From: Simon Foster [REDACTED]
Sent: 04 February 2024 12:25
To: Fay Humpherson
Subject: [EXTERNAL] RE: Planning application SI/24/00008/DOM
Attachments: Shed elevations.docx; Shed elevations.pdf; Shed floorplans.docx; Shed floorplans.pdf

From: Fay Humpherson <fhumpherson@chichester.gov.uk>
Sent: Wednesday, January 24, 2024 12:15 PM
To: Simon Foster [REDACTED]
Subject: Planning application SI/24/00008/DOM

Thank you for your email regarding the validation of planning application 24/00008/DOM.

Drawing number PL02 Rev. A

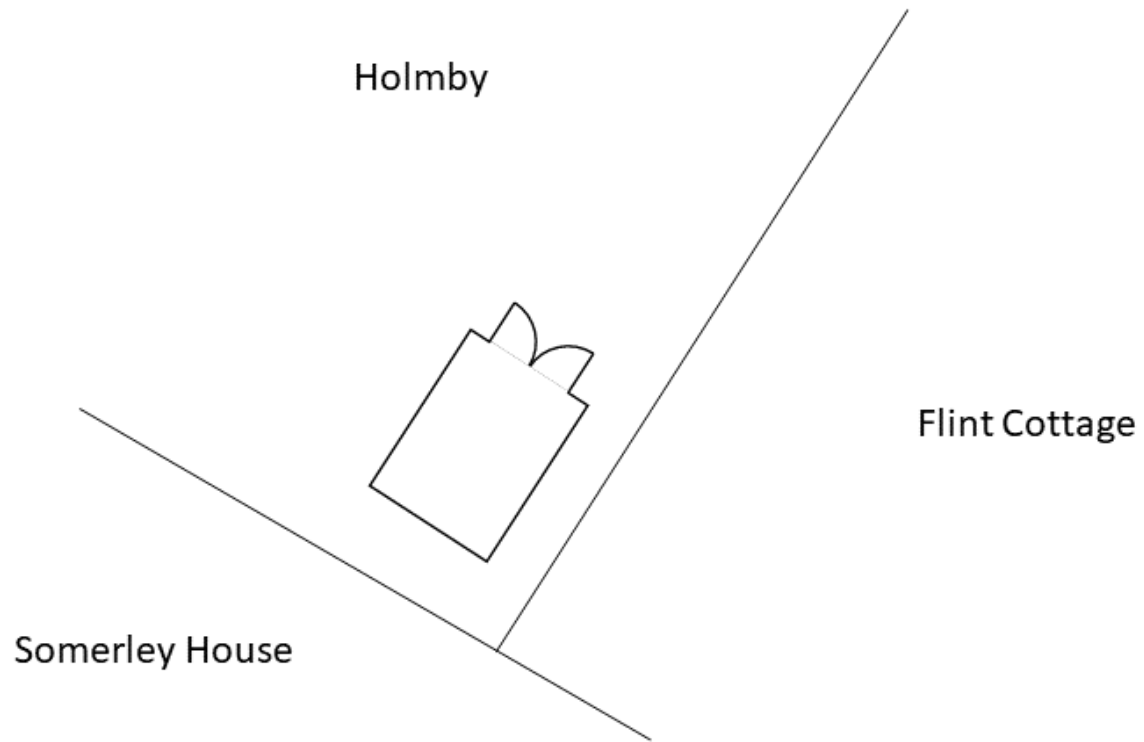
Aspect 5: Please review and amend the replacement floor plan provided as the copy of the document provided has not been formatted to A4 paper size, as has been stated.

Aspect 5: Please see the attached floor plan, reformatted to the correct A4 size. I have included both Word and PDF version in case there is still a problem with the PDF

Holmby shed

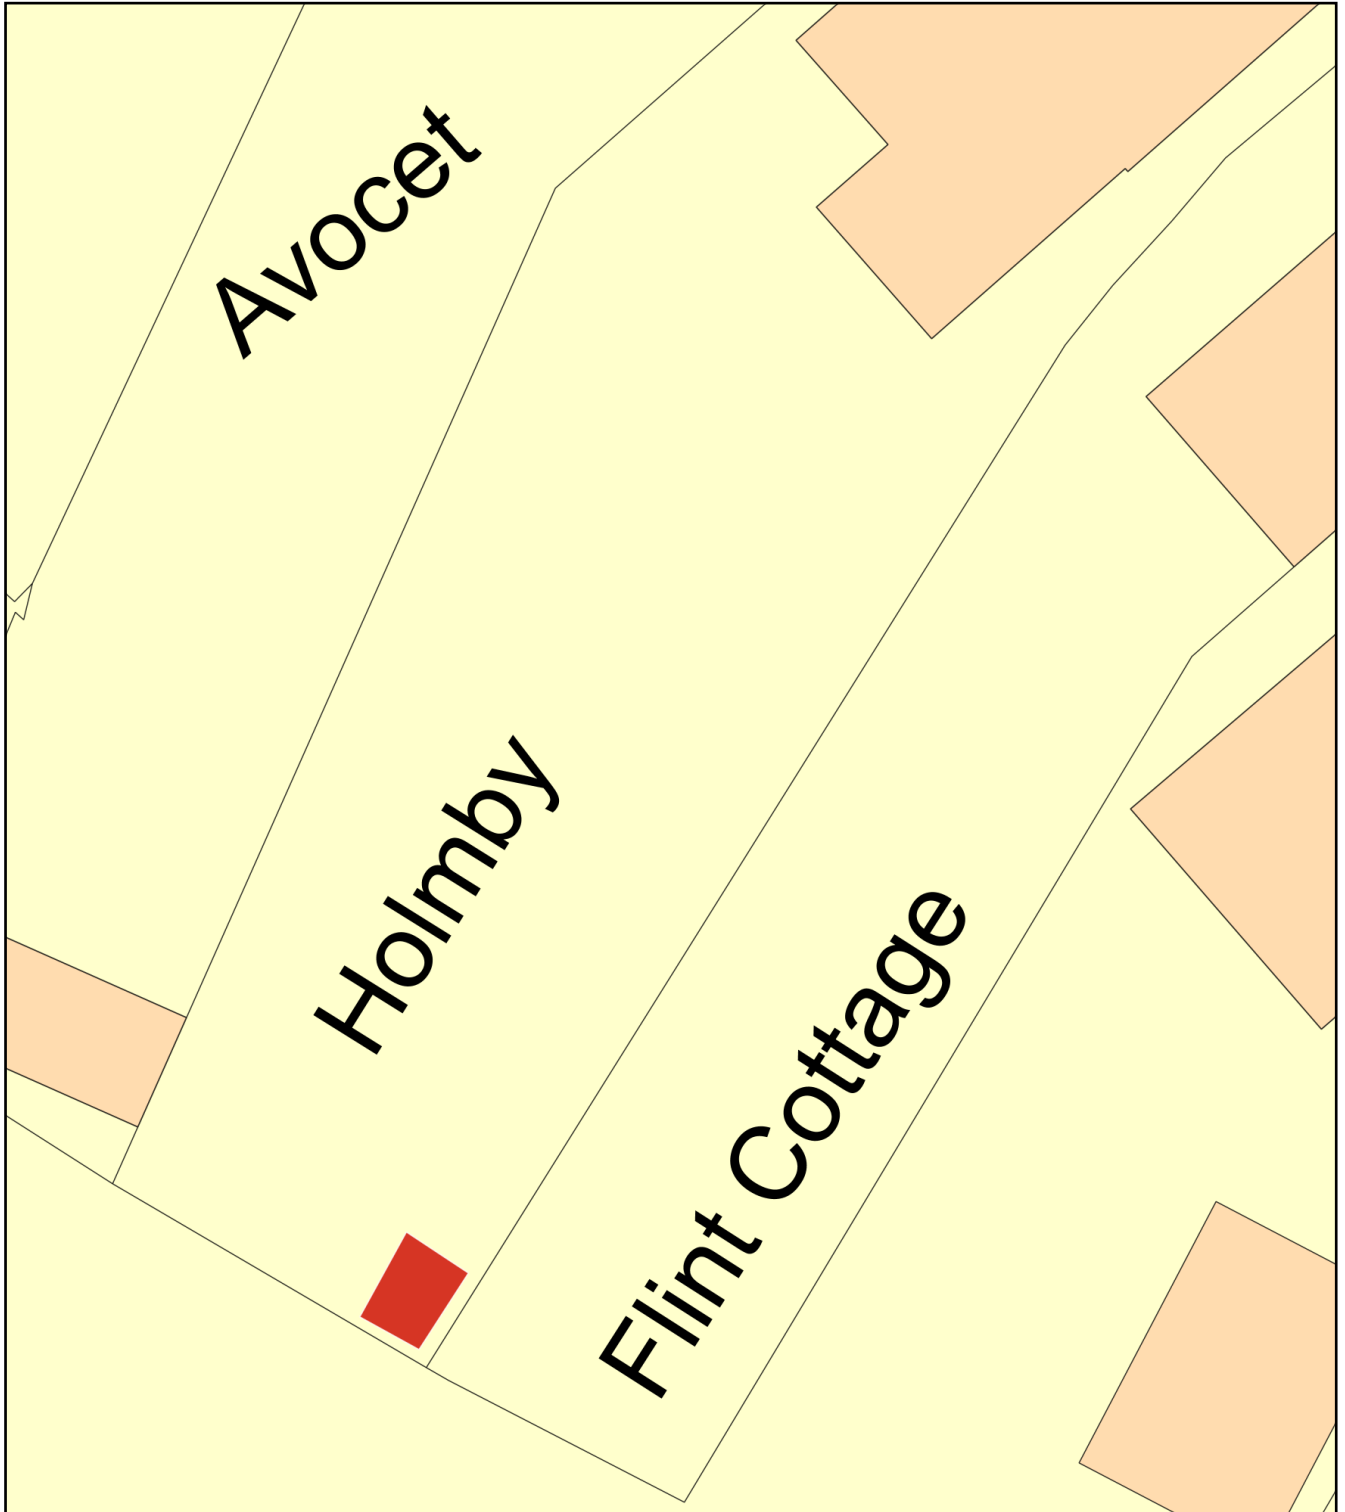
Aspect 2b: With respect to the above, please can you also provide written confirmation for the application documents to include the submission of the original Location Plan (see attached), rather than the annotated replacement.

Aspect 2b: I agree that the application documents should include the submission of the original Location Plan.
